April 28, 2006

**Subject: Office Renovation Review
Portland Water District
Portland, Maine**

Thank for choosing E.S. Coffin Engineering & Surveying, Inc. to perform a review of the proposed plans for the office renovation at the Portland Water District located in Portland, Maine. The following review is based on the proposed plans provided by Choice Design and structural plans of the existing building provided by Ganneston Construction.

FIRST FLOOR RENOVATIONS

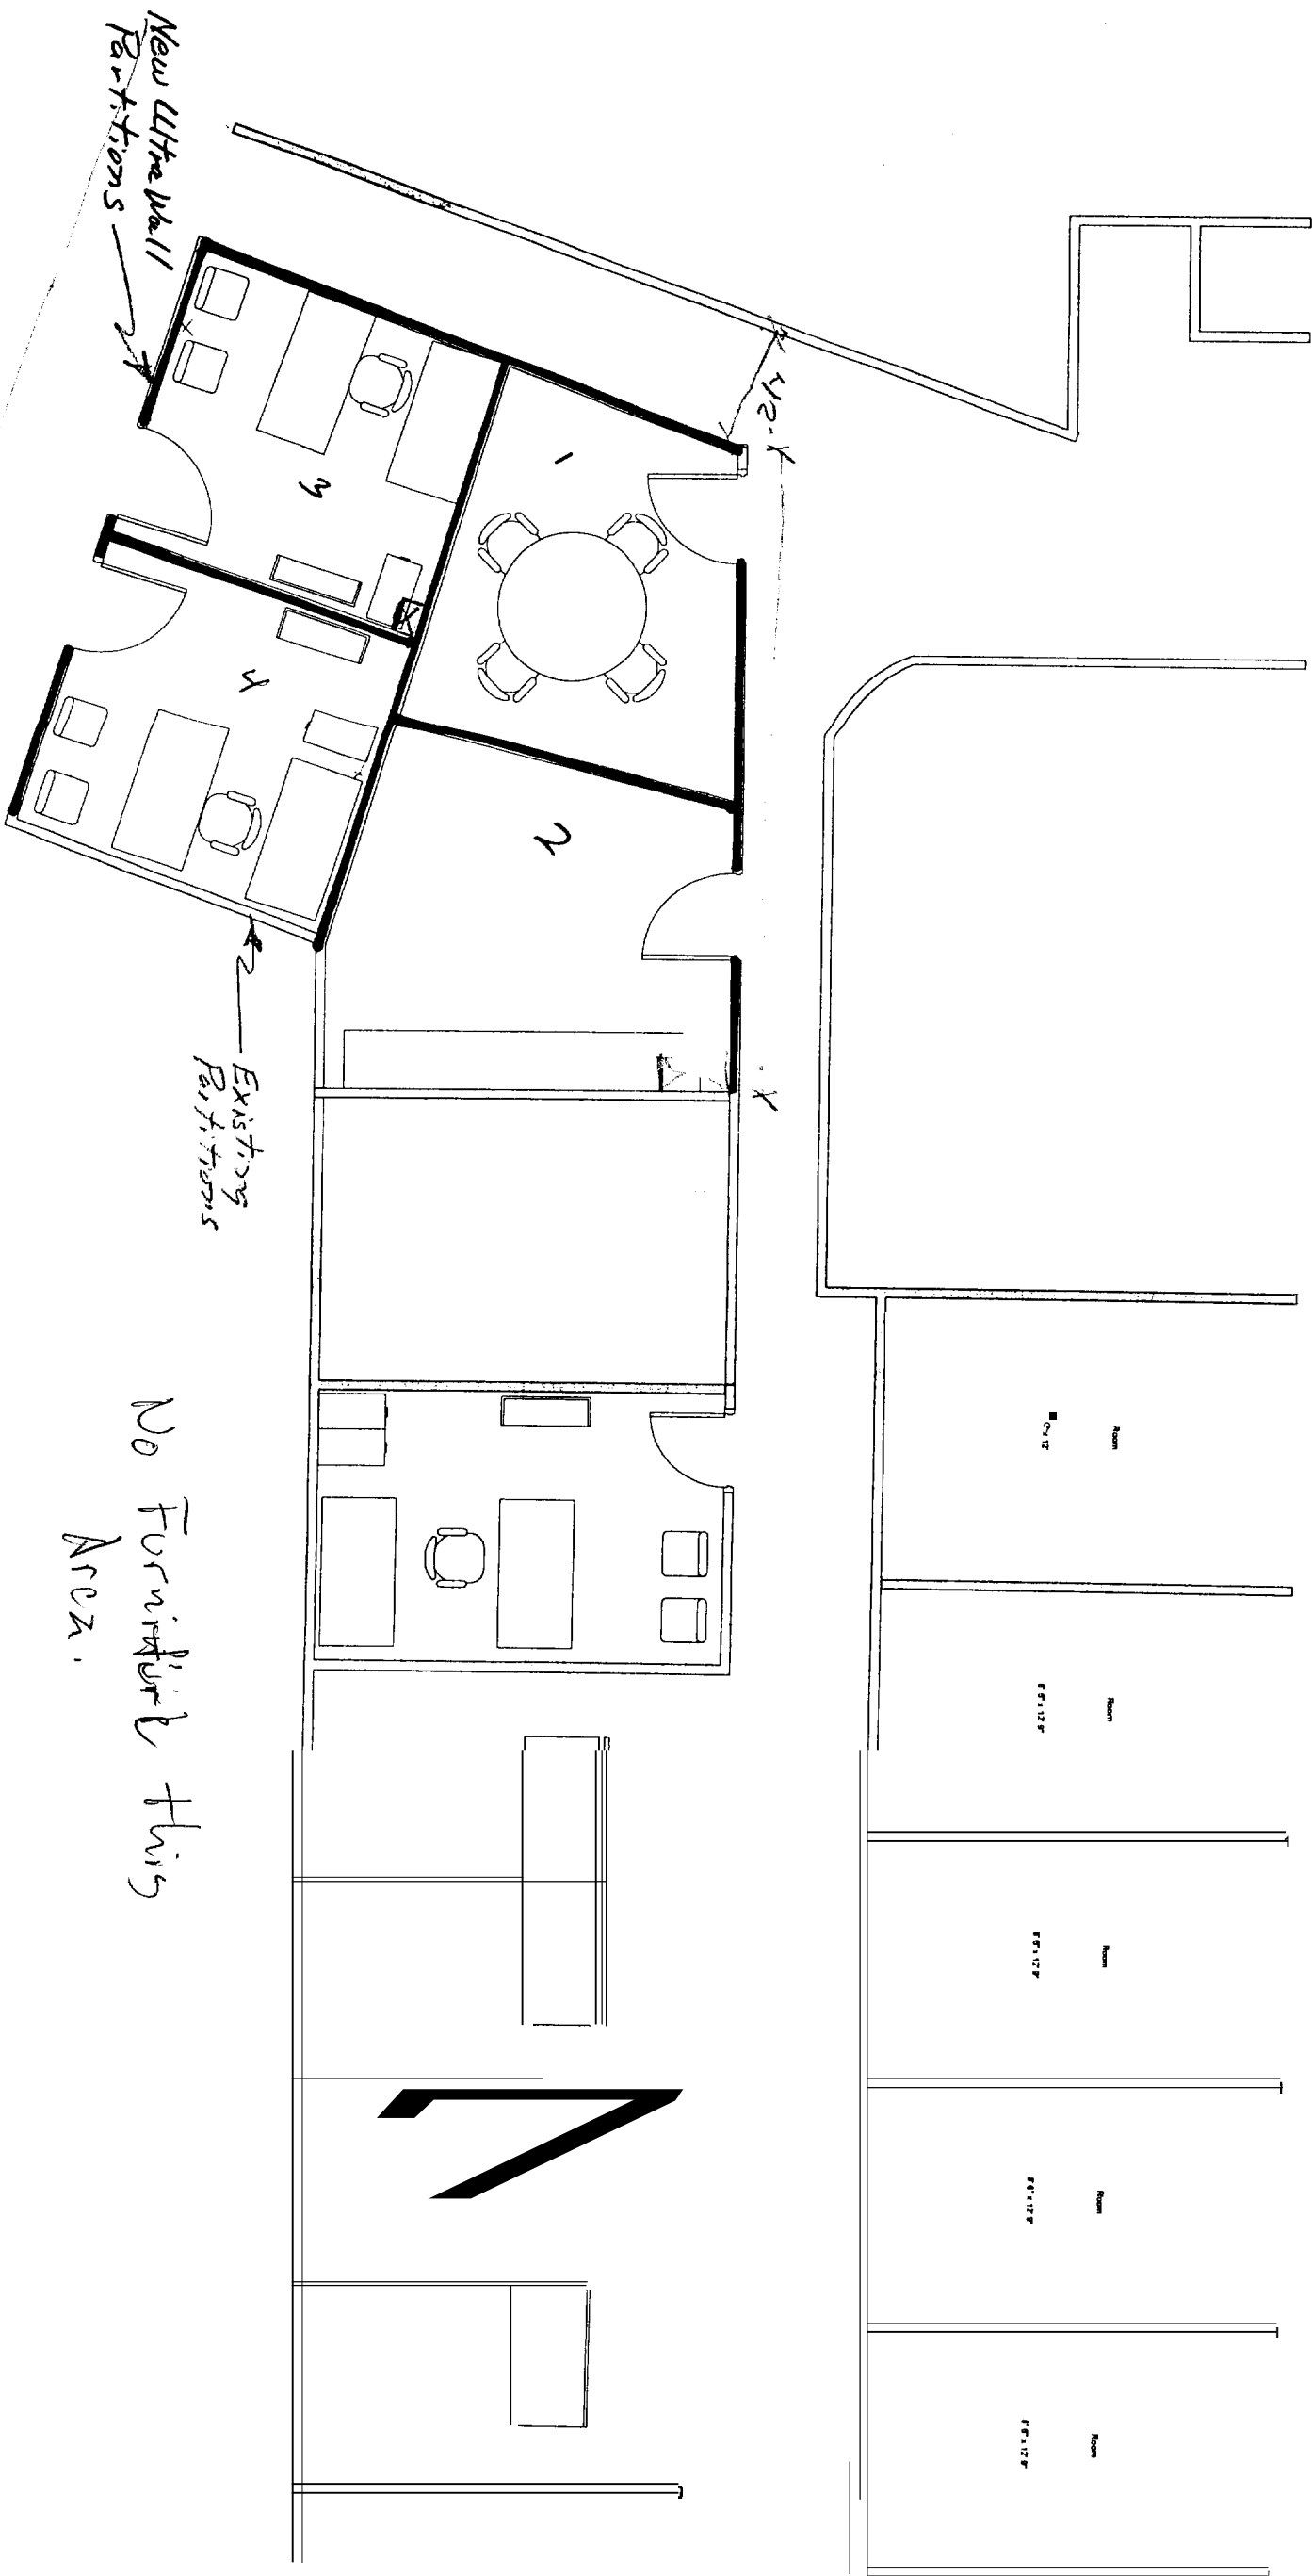
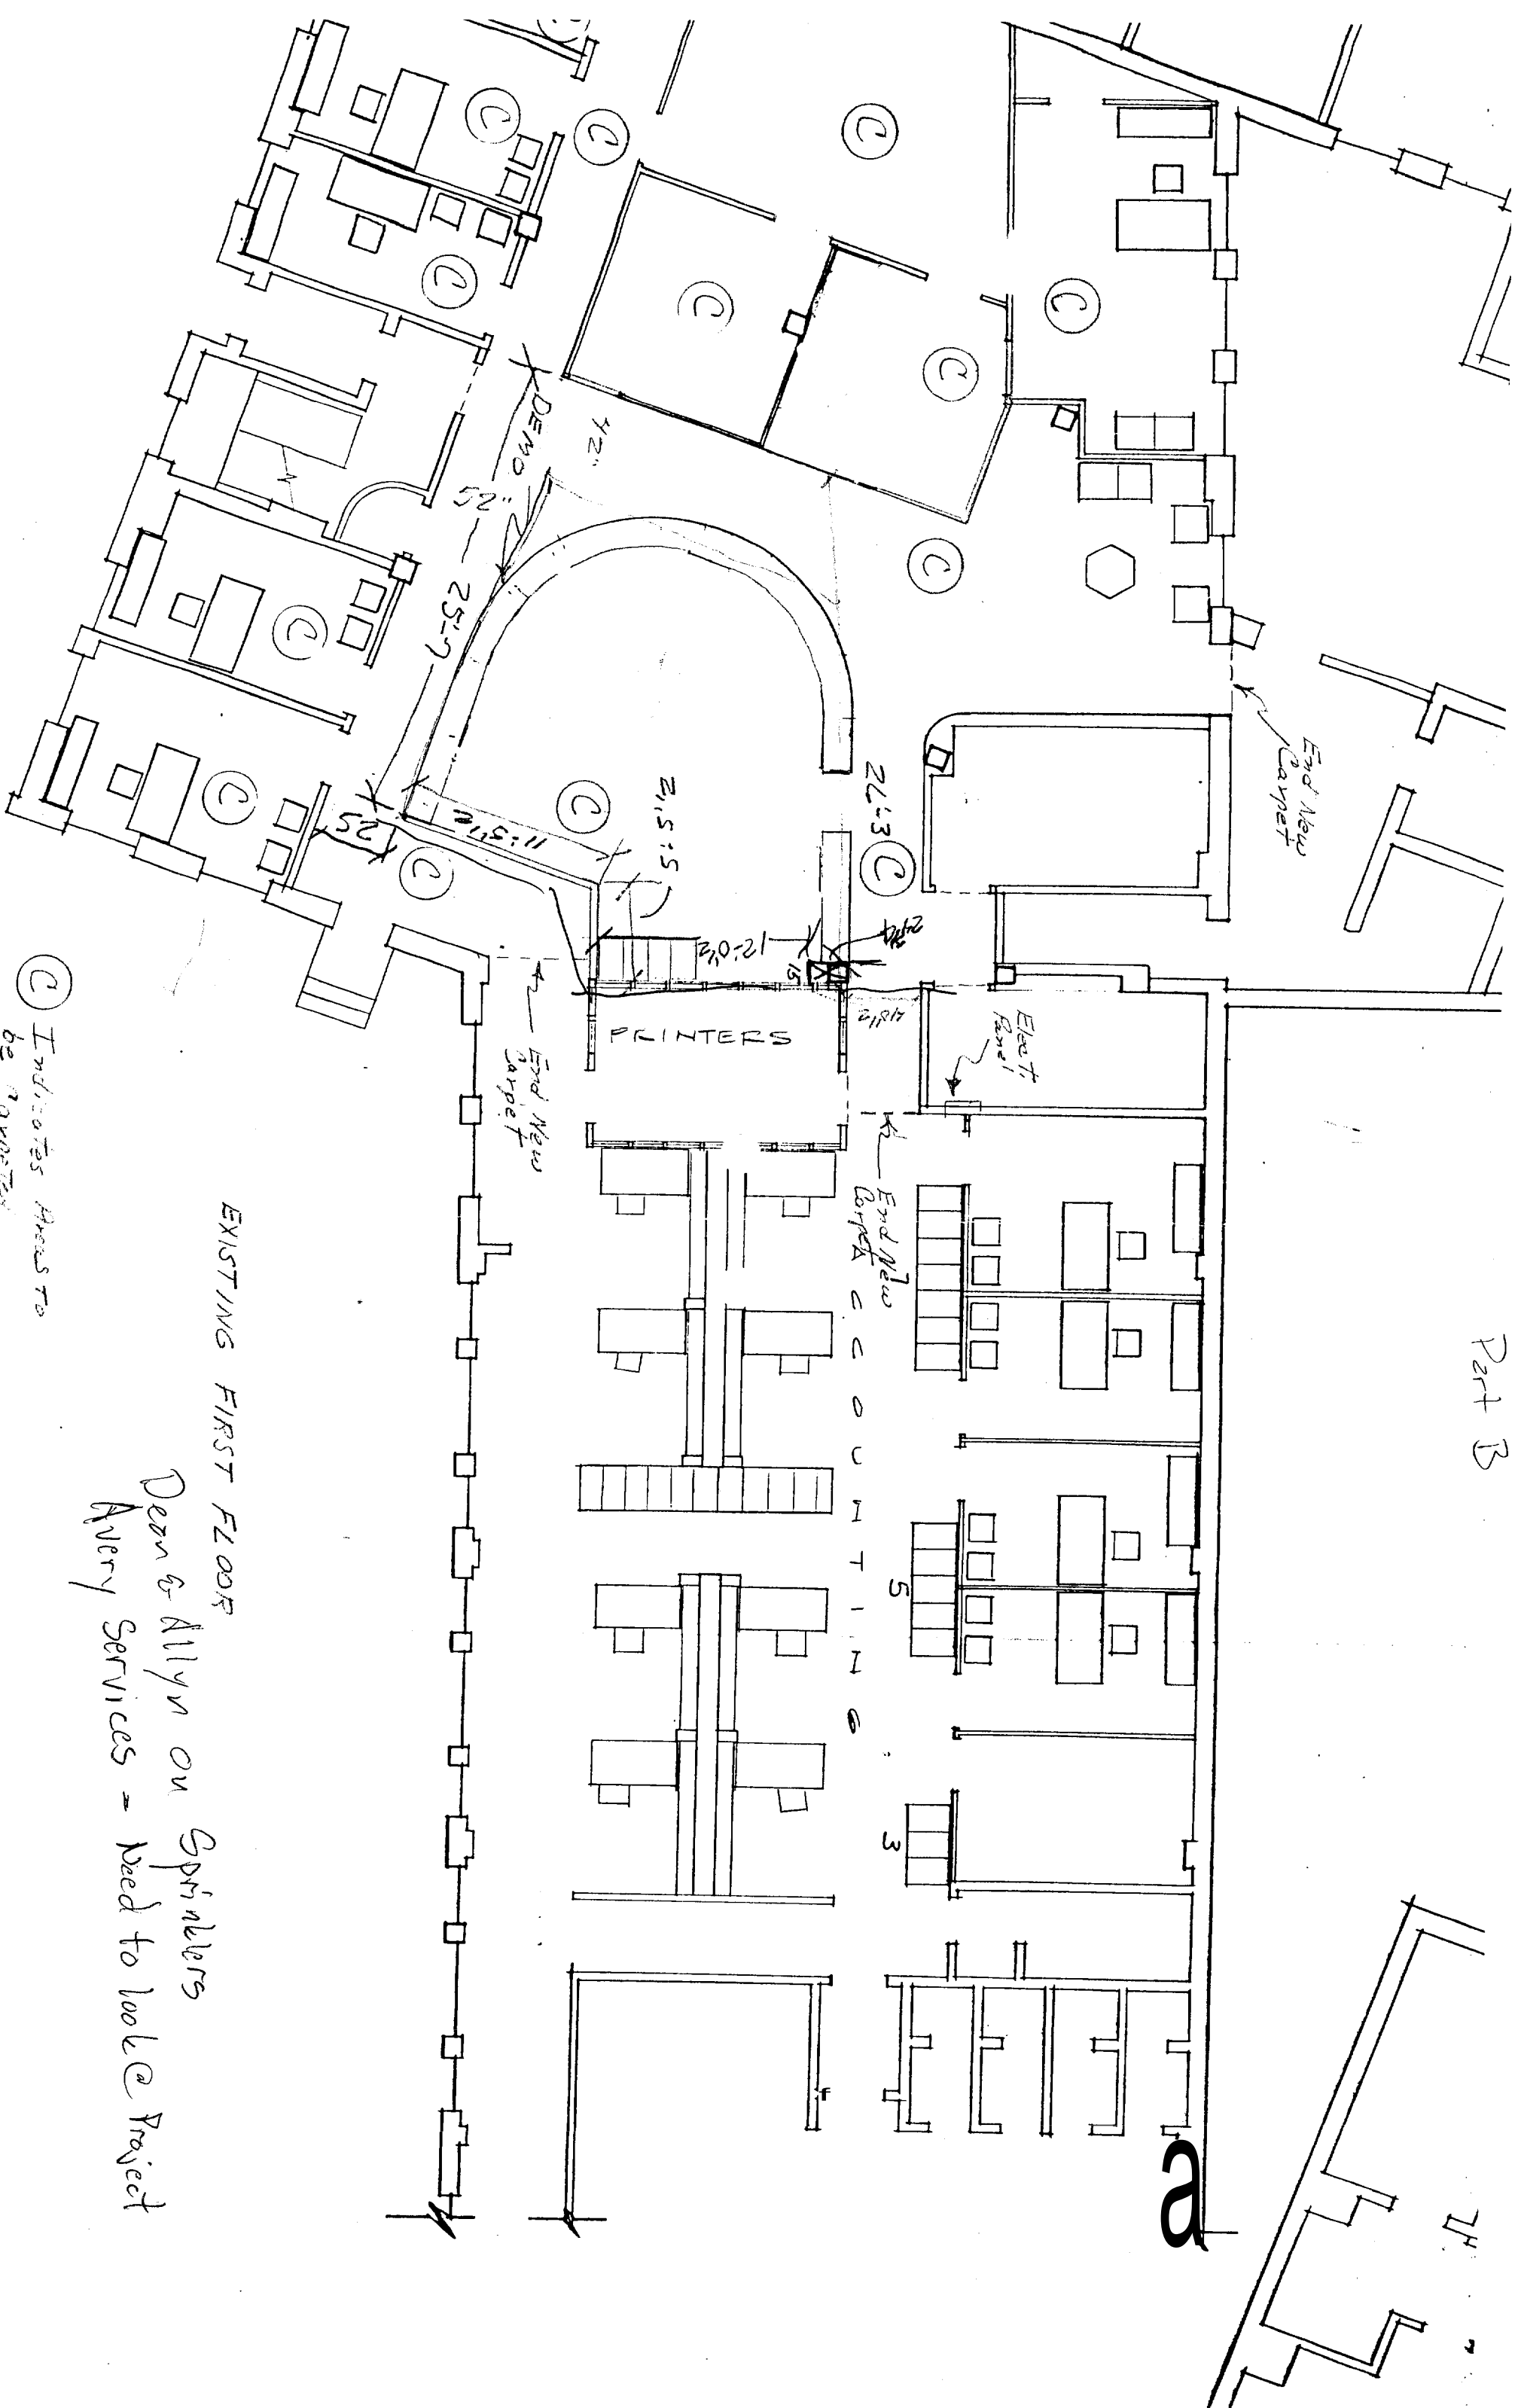
A review of the proposed plans found that the renovation on the first and second floor do not restrict egress paths or create dead end corridors in reference to the requirements of the NFPA Life Safety Code. We recommend that emergency lighting be installed in the hallway on the first floor along the back wall. Emergency lighting also needs to be installed on the second floor hallway to illuminate the existing egress door at the end of the hallway. We also recommend that the closet in the conference room be shortened in order to allow for a minimum of 18" clear on the pull side of the door into the conference room. This review is based on the partial drawings provided. We have not conducted a full Life Safety Code or **ADA** review of the building.

Once the plans have been revised to show the changes described above, we will stamp the plans for submission to the City of Portland. If you have any questions, please feel free to call me at 623-9475.
